July 19, 2007

**RE: Harnett County Land Use Application HTE #07-5-17993 Lt 257 Crestview
#07-5-17995 Lt 258 Crestview**

On July 19, 2007 an attempt was made to evaluate your property for the purpose of issuing an Improvement Permit. The evaluation could not be completed for one or more of the following reasons.

CUMBERLAND HOMES, INC.
THE CAPE WITH SUNROOM
LOT # 258 CRESTVIEW
SCALE: 1"=50'

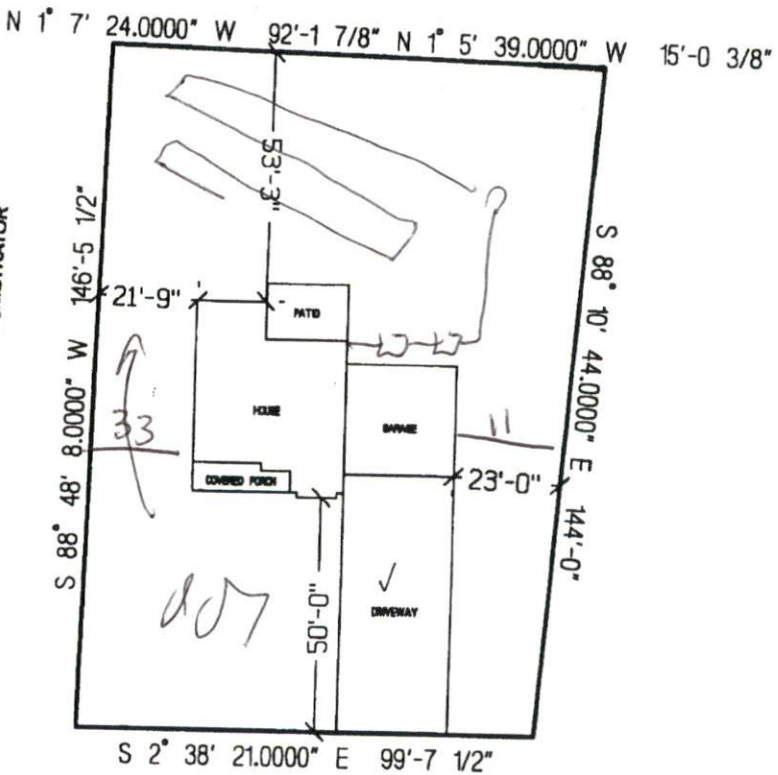
Move house as shown on the attached and submit new plot plan to Central Permitting
